Planning Consultation Memo

| Date | Planning Officer | Environmental Health Officer |
|-----------------------------|------------------|------------------------------|
| 6/2018/1186/FULL | WK/98734 | |

Address: 11 Northaw Park Hook Lane Potters Bar EN6 4DA

Application Details: Subdivision of existing single dwelling into two dwellings, with the installation of a front door and window to facilitate conversion of a garage into a hall, corridor and utility room

PLAN 8

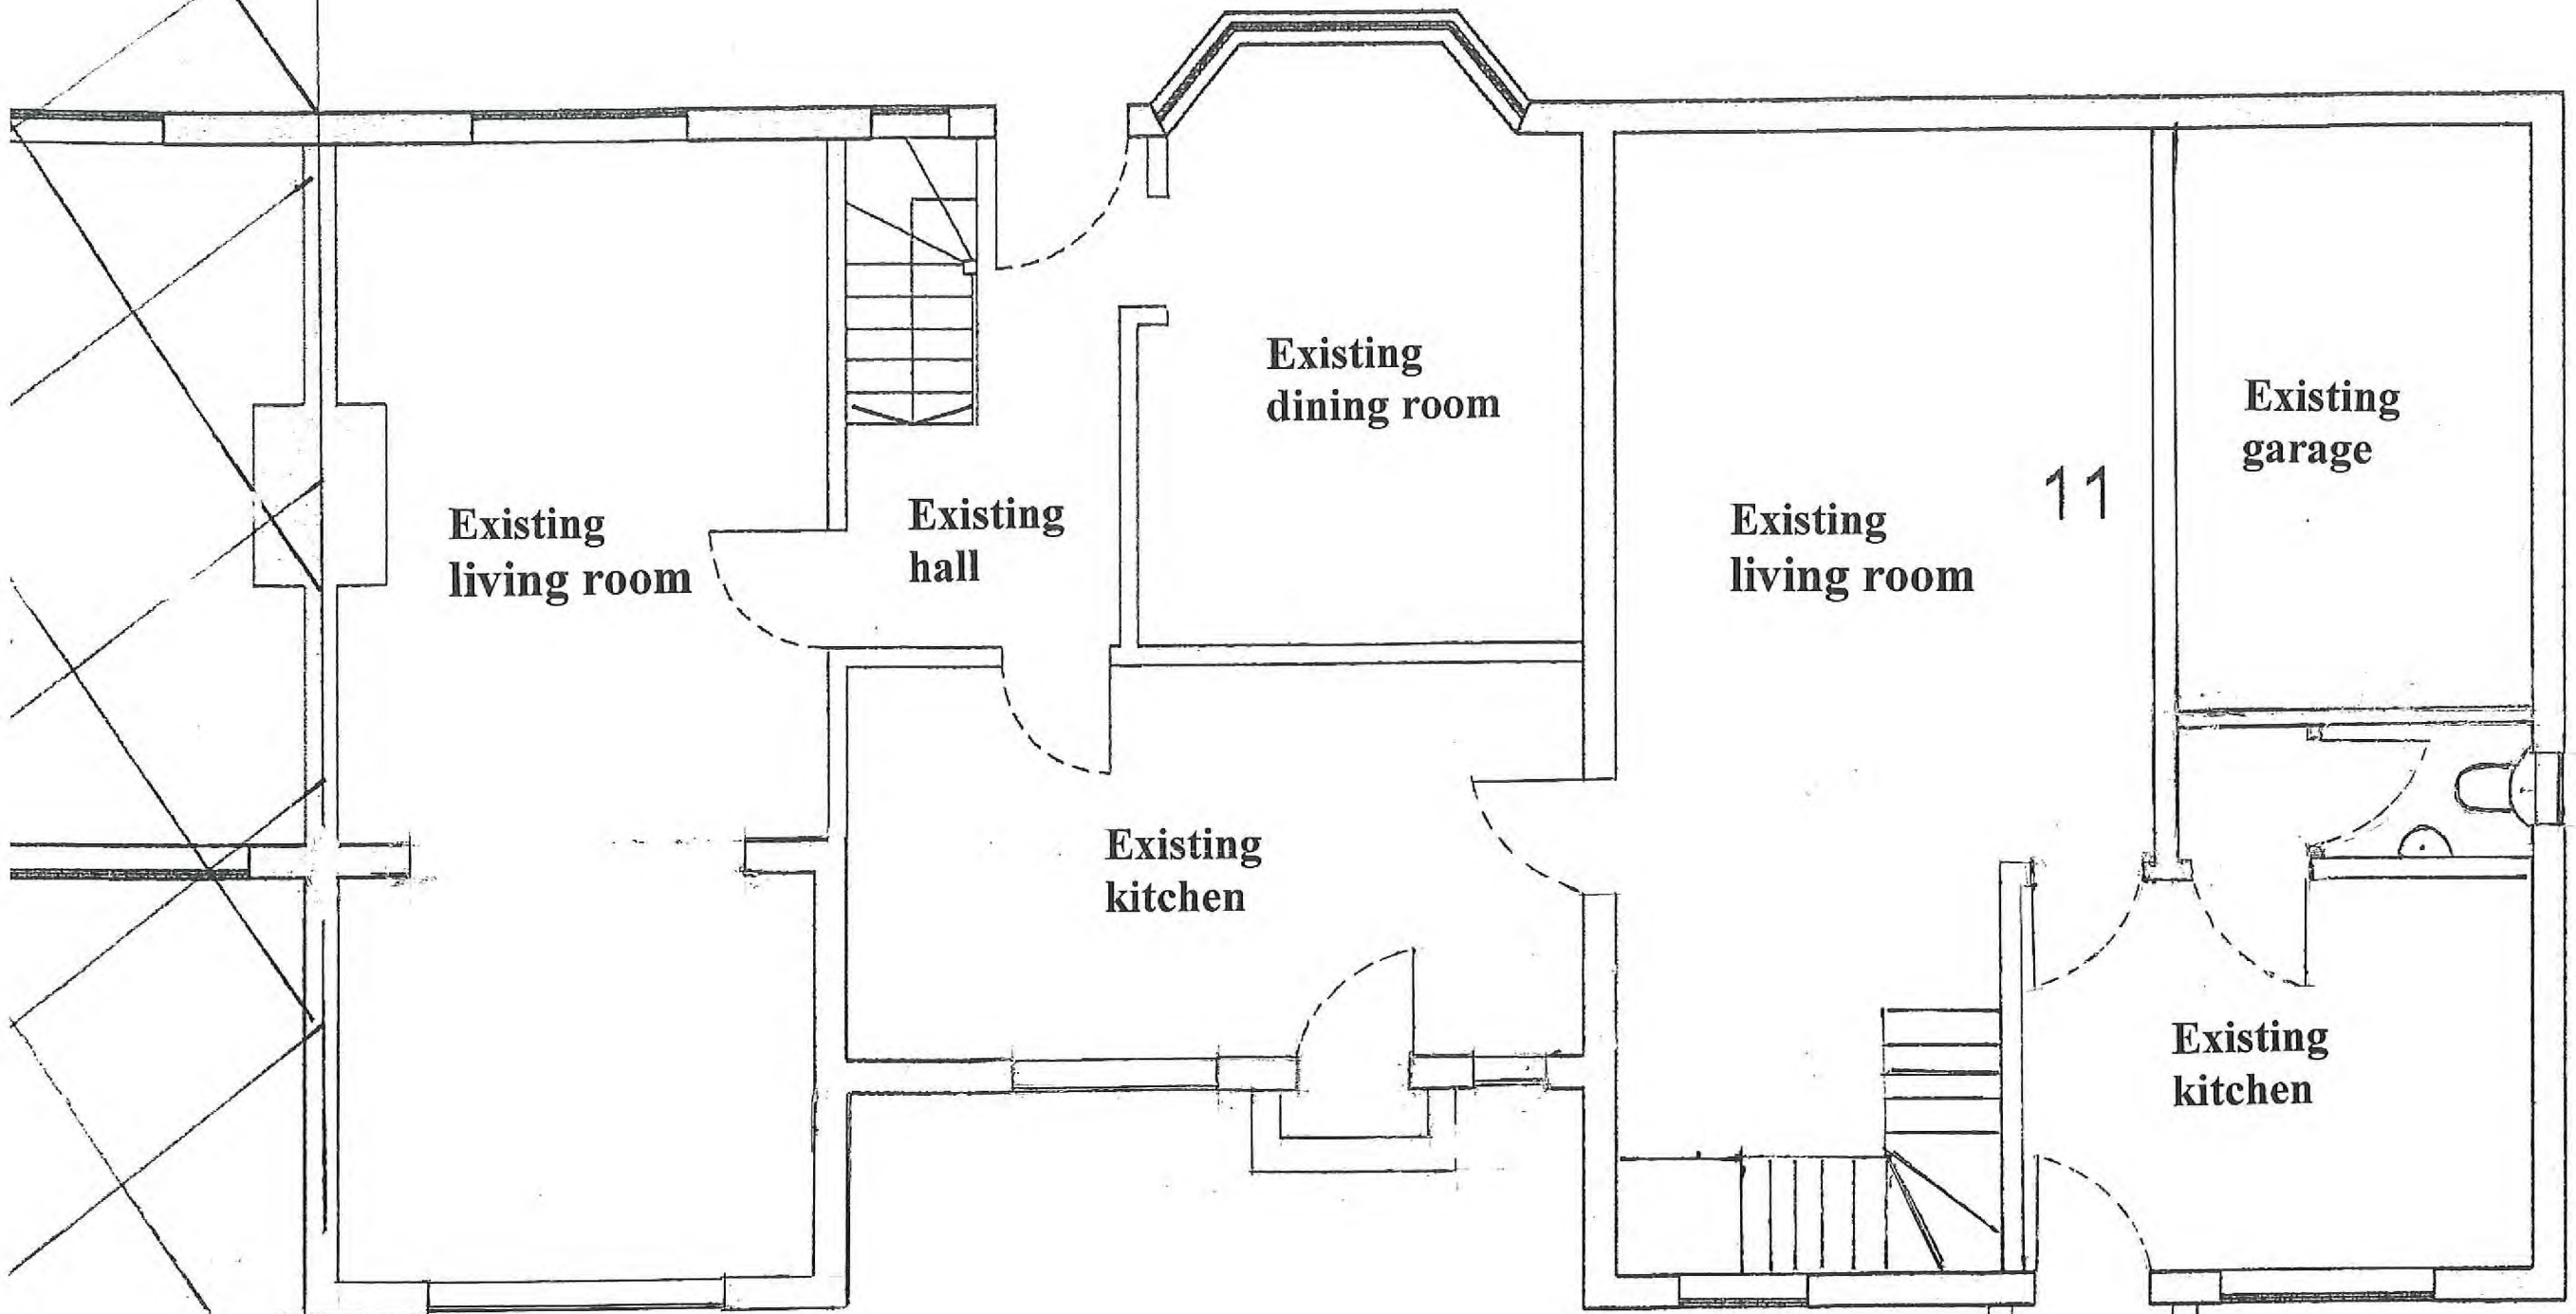
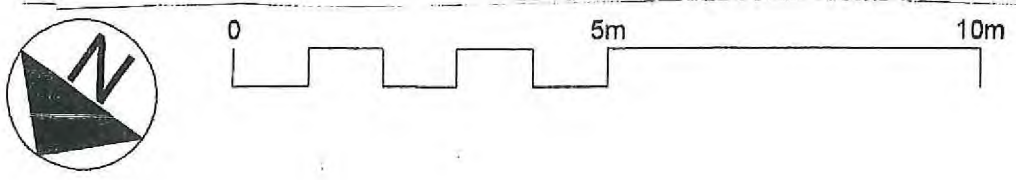
The house is semidetached which will limit the transfer of noise to other existing properties in the locality with the main concern being for the direct neighbours. Looking at the existing and proposed layouts, there is very little change to the layout, and the main changes are taking place at the furthest point from the attached neighbouring property. As such, it is unlikely that there will be any noticeable impact from the proposed changes.
